**WEST SUSSEX COUNTY COUNCIL
PLANNING SERVICES CONSULTATION**

**TO: Arun District Council
FAO: Ross Leal**

SUBJECT: CM/33/17/PL- Demolition of prefabricated former private school building and Mill Lodge residential unit. Refurbishment of existing Mill to retain and refurbish existing dwelling and flats 1 & 2 (adjoining) with 2No. additional dwellings. Refurbishment of Mill Cottage and Mill Thatch (units 1 & 2) and erection of 1No. new-build floating pond-house within feature pond. Departure from the Development Plan. This application also lies within the parish of Littlehampton and affects the setting of a Listed Building.

Clymping Mill, Climping Street, Climping, West Sussex, BN17 5RN

Drawing No.	Drawing Title:
2	Site Plan

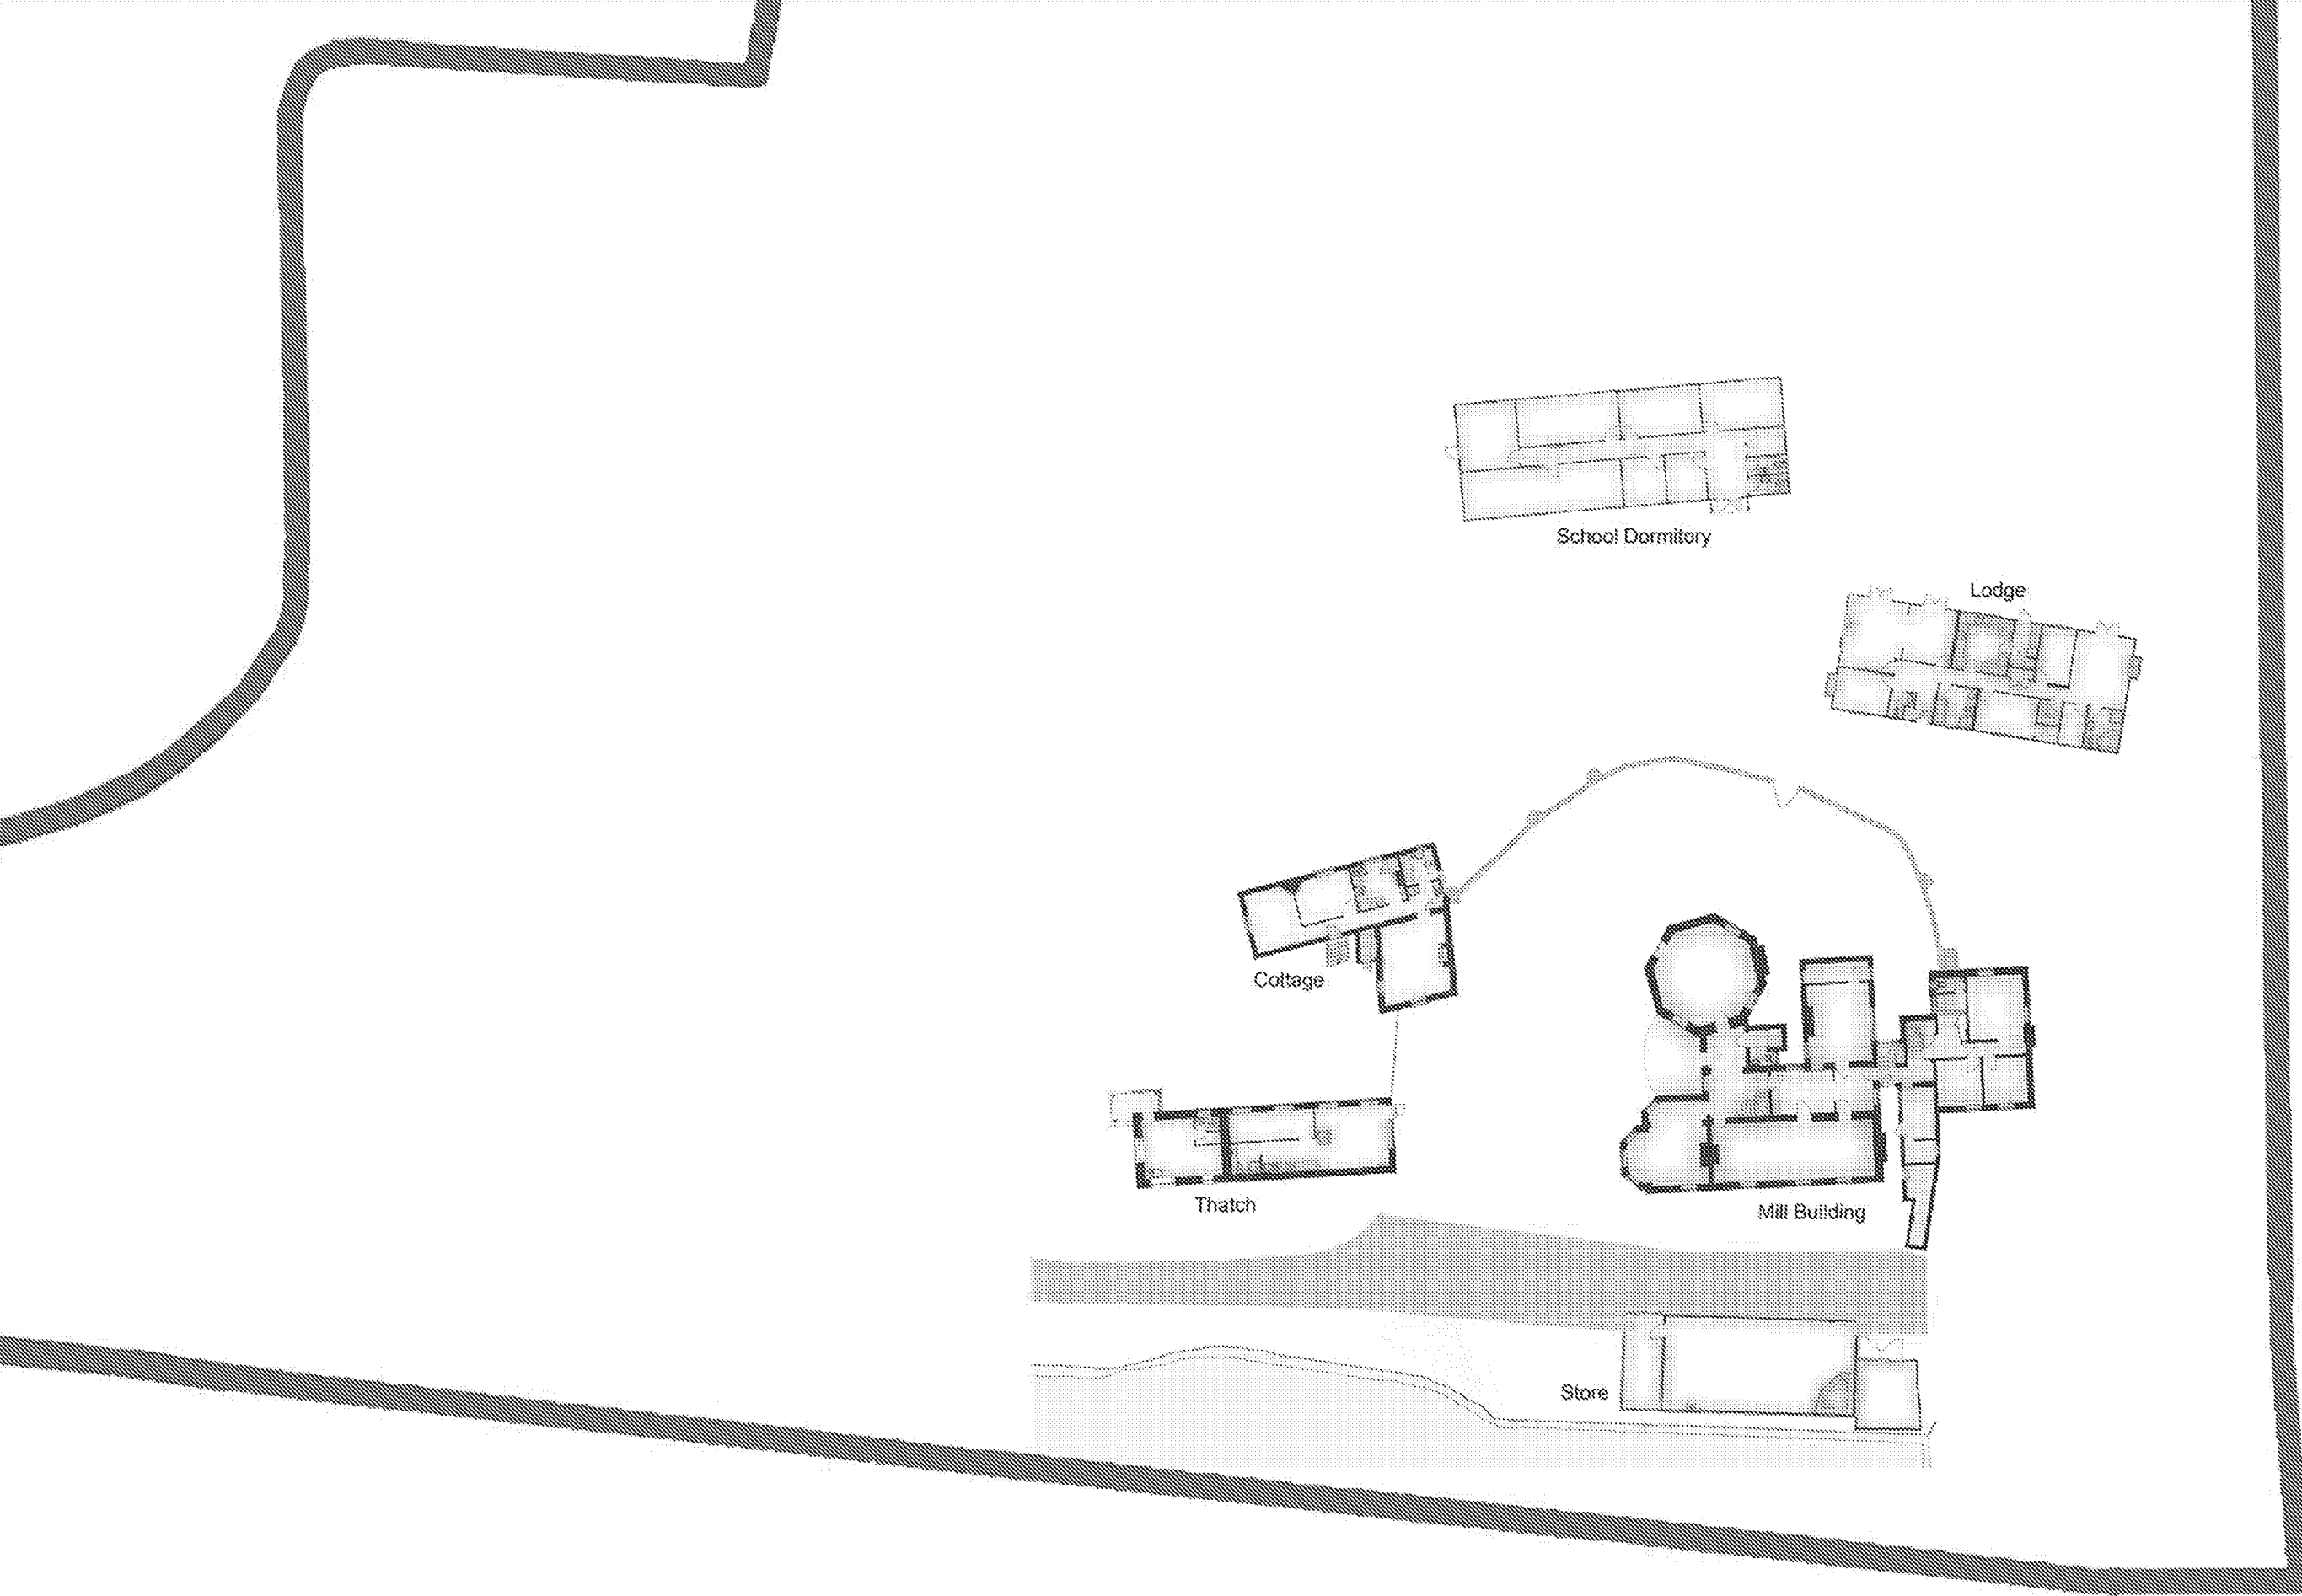
The Local Highway Authority requires swept path diagrams demonstrating that refuse and emergency vehicles are able to turn on the site to exit in a forwards gear. The applicant has outlined that a hammerhead is available for this to occur however this should be demonstrated given the ability for vehicles to be parked in this location also, as shown in the location plan.

The applicant should also demonstrate the ability for this manoeuvre to take place in the car park serving the Pond House as well as Mill Buildings as refuse will be required to be collected from each dwelling.

The plans are required to demonstrate this manoeuvre is achievable should the parking spaces shown be occupied by residents.
